Our ref: PL00490033

Your ref: EN010092

**PLANNING ACT 2008 : THURROCK POWER, PROPOSED THURROCK FLEXIBLE
GENERATION PLANT**

Historic England Deadline 4 Response

Figure 2.2 ZTV and designated heritage assets within a 5km buffer of Zone A

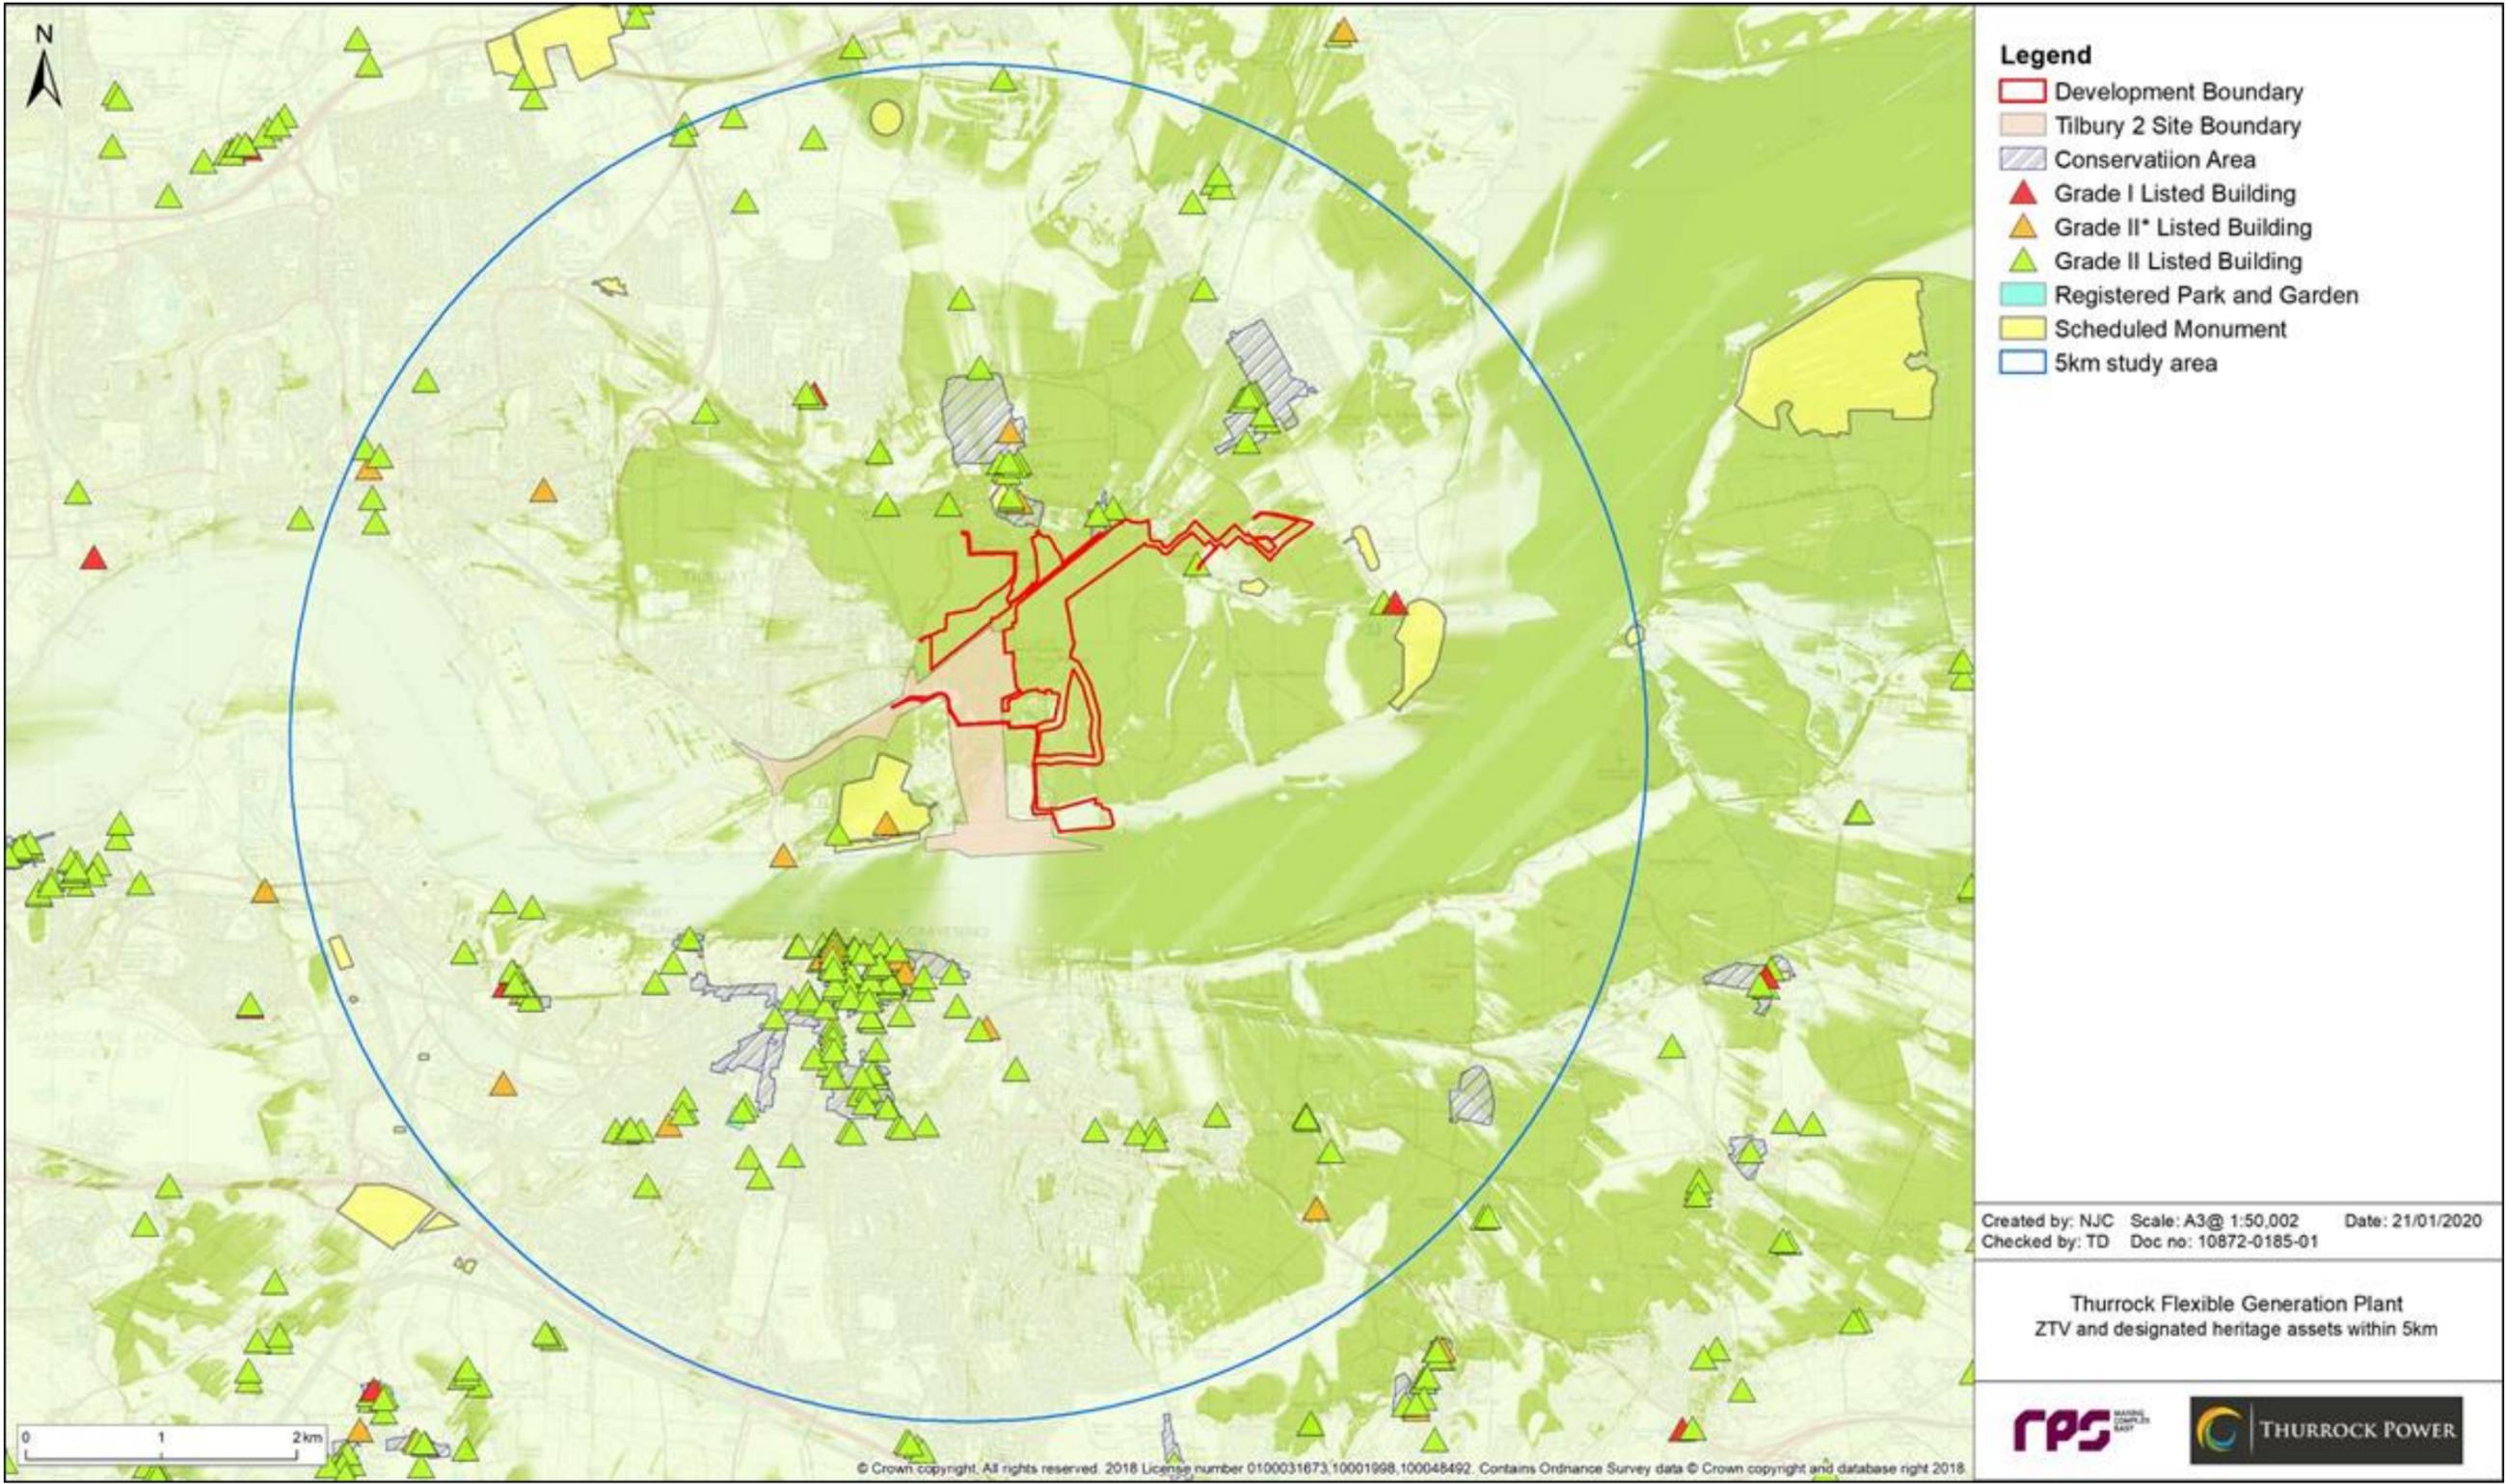
We believe the impact of the scheme has been represented as less than it is for the scheduled monuments known as 'Earthworks near church, West Tilbury' and also the Grade II* Listed Church of St James. In terms of the magnitude of impact on the scheduled monument, the ES states the scheme will comprise a minor change to the wider setting of the monument. The significance of effect of the scheme on the setting

We believe the development would adversely affect the experience of these designated heritage assets in their landscape setting and would be more harmful; both the magnitude of impact and the significance of effect in both cases is moderate to high – and certainly not minor.

This is because the significance of both designated draws much from their setting, located in similar prominent and striking topographic locations. Indeed, the panoramic engraving of 1739 by Samuel and Nathaniel Buck, [The North Prospect of Gravesend in the County of Kent](#), views Tilbury Fort and Gravesend from a similar location to ES Viewpoint No. 7 on Hall Hill, from the scheduled monument known as ‘Earthworks near church, West Tilbury’.

In our opinion, the overall change to the built surroundings, skyline and the spatial quality of views would be dramatic due to the form, massing and height of the development and its industrial character. The proposed development would, we believe, significantly erode part of the setting, and compromise the appreciation, of both these designated heritage assets on a key sight line to the south-west towards Tilbury Fort.

Figure 3.1 Recorded heritage assets within a 3km study area around the main development site

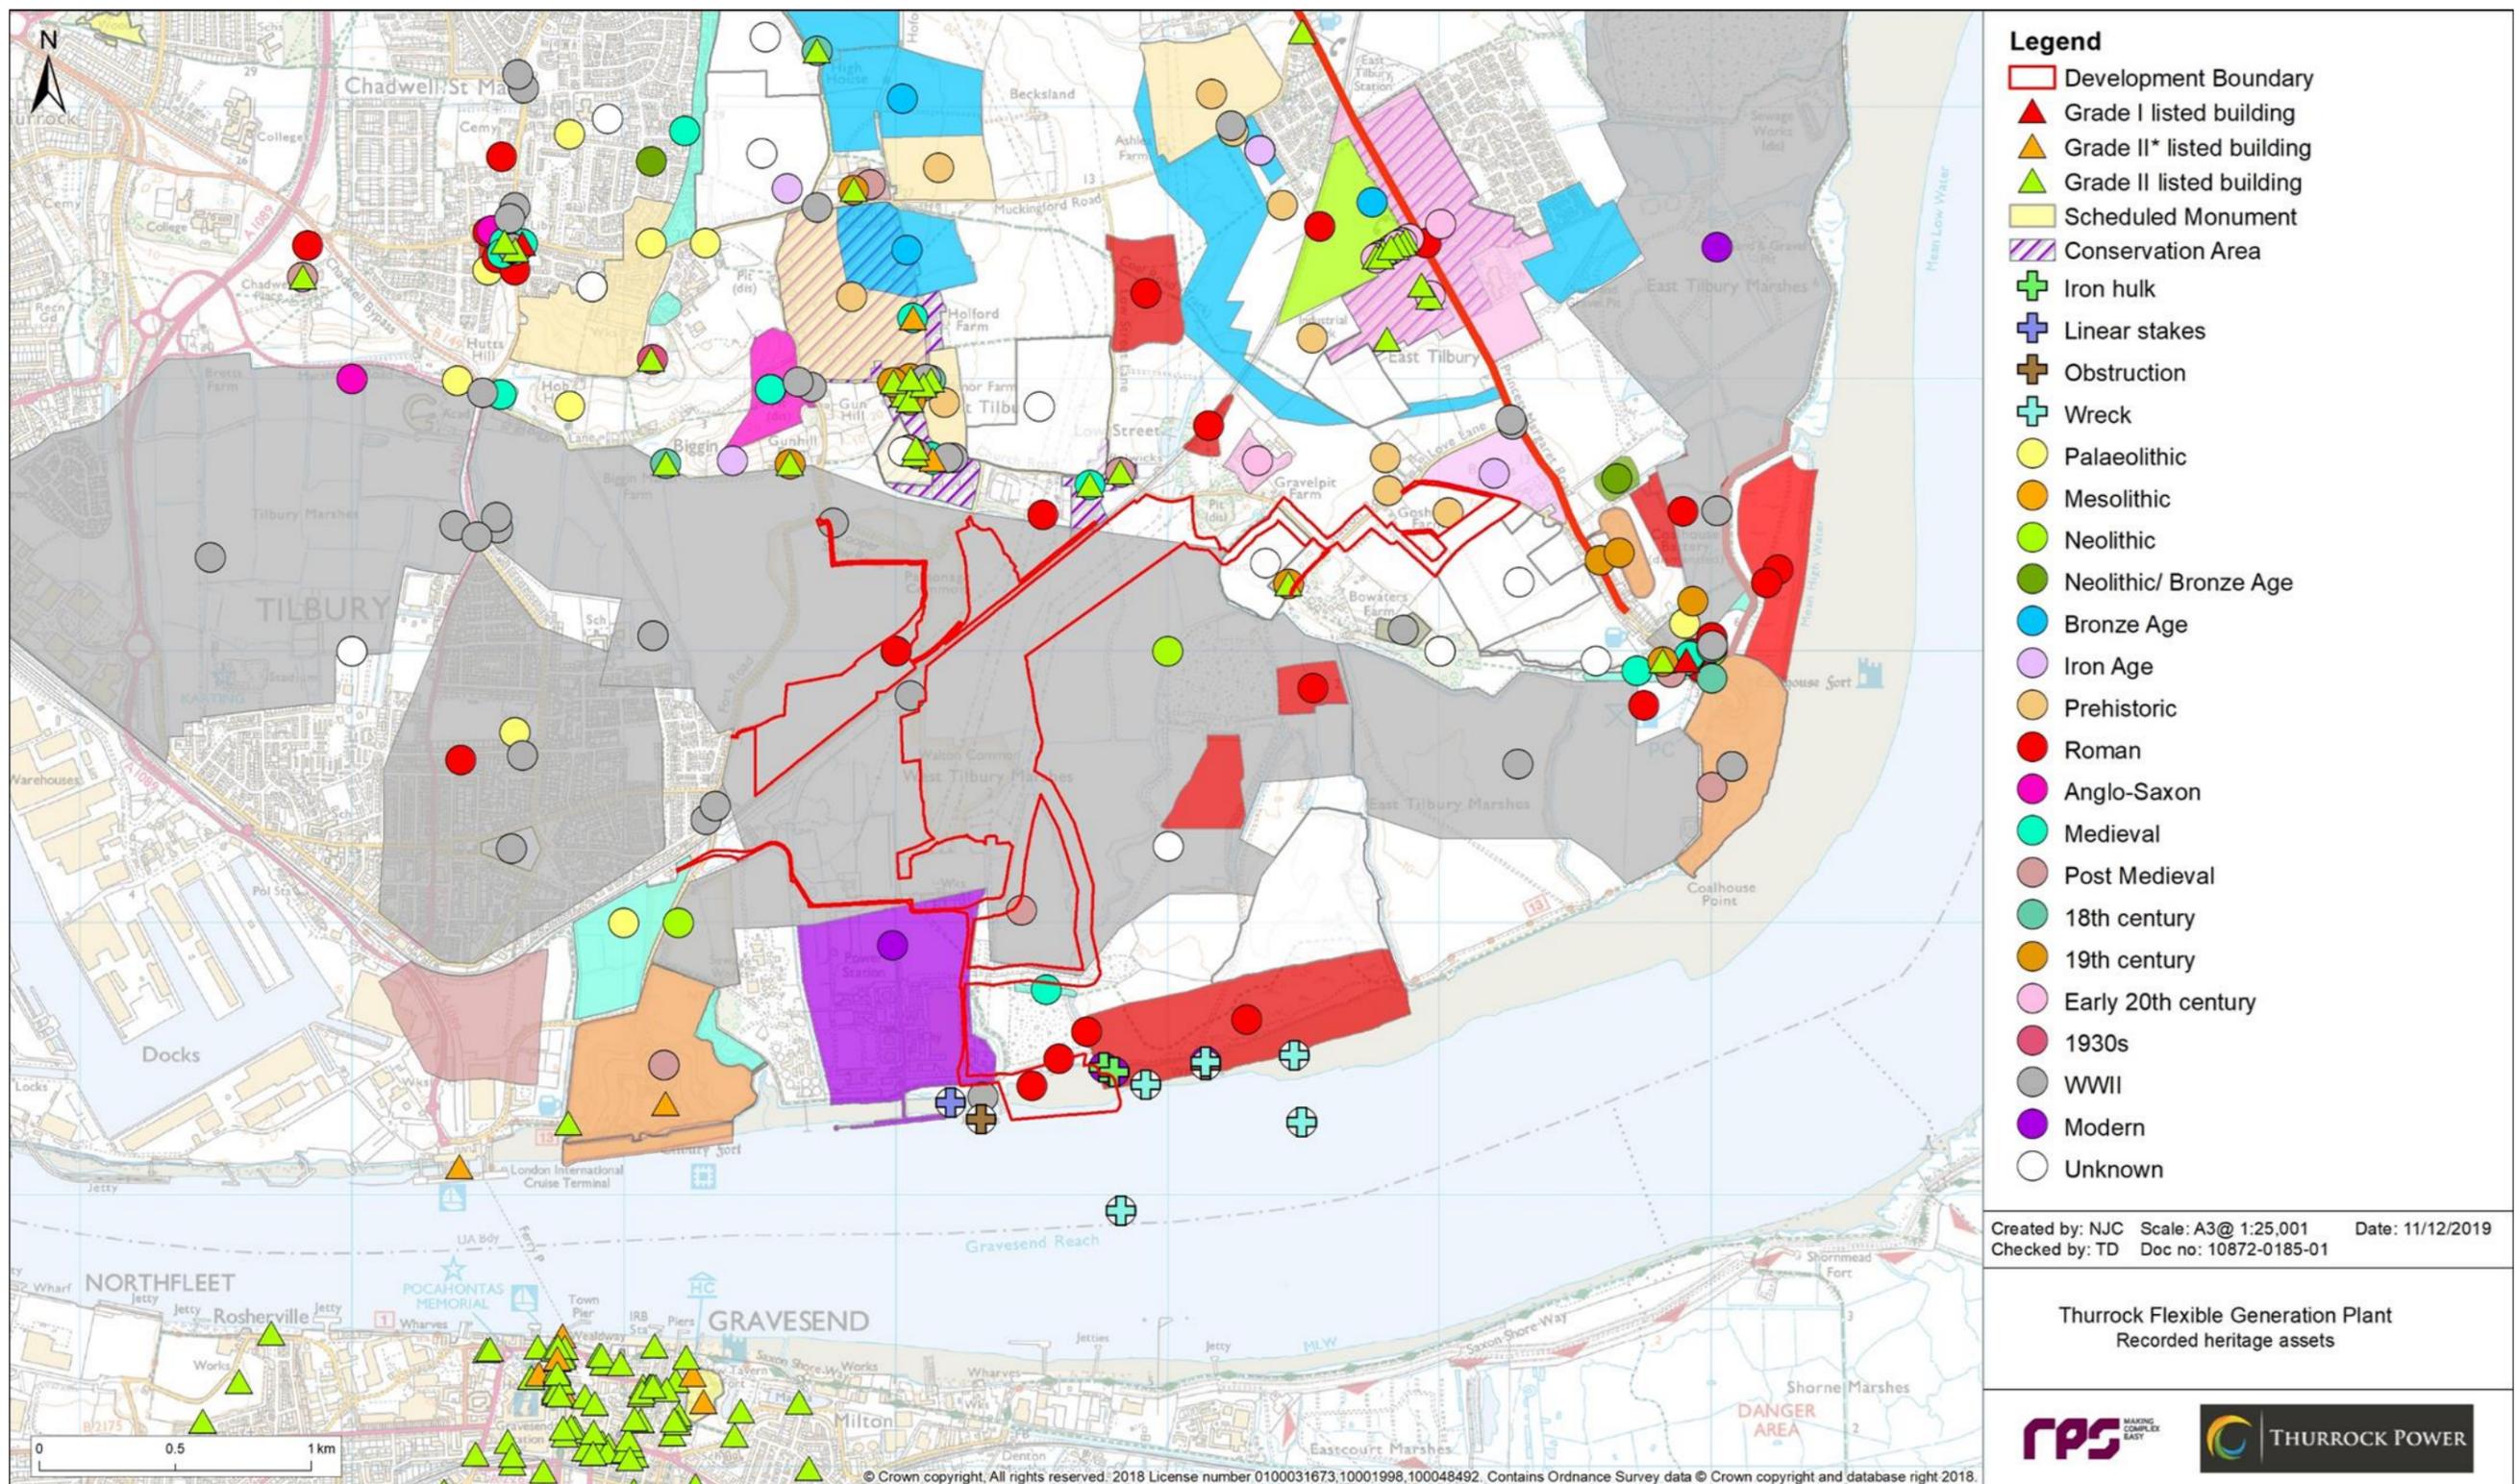
We believe the applicant has failed to adequately assess the significance of the below-ground archaeological remains that are suspected by geophysical survey to be present within the development area.

Furthermore, the main development site, Zone A, is significantly larger than the area of Walton Common and the Commons Act does not prevent trial-trenching across the remaining half of Zone A as well as in other parts of the proposed development area, where groundworks will be undertaken and where there is potential to disturb and damage buried archaeological remains, including Zones C, D, F and G.

At this stage, we strongly suspect there are likely to be archaeological remains within the development area, as they have been indicated by the geophysical survey. These are potentially well-preserved in the area of the historic common - this is because of the relatively benign land use of commons and we know from elsewhere this can lead to the good preservation of the remains of earlier periods. Here, these can be easily and rapidly assessed by trial-trenching - as is currently being undertaken for the adjacent LTC project.
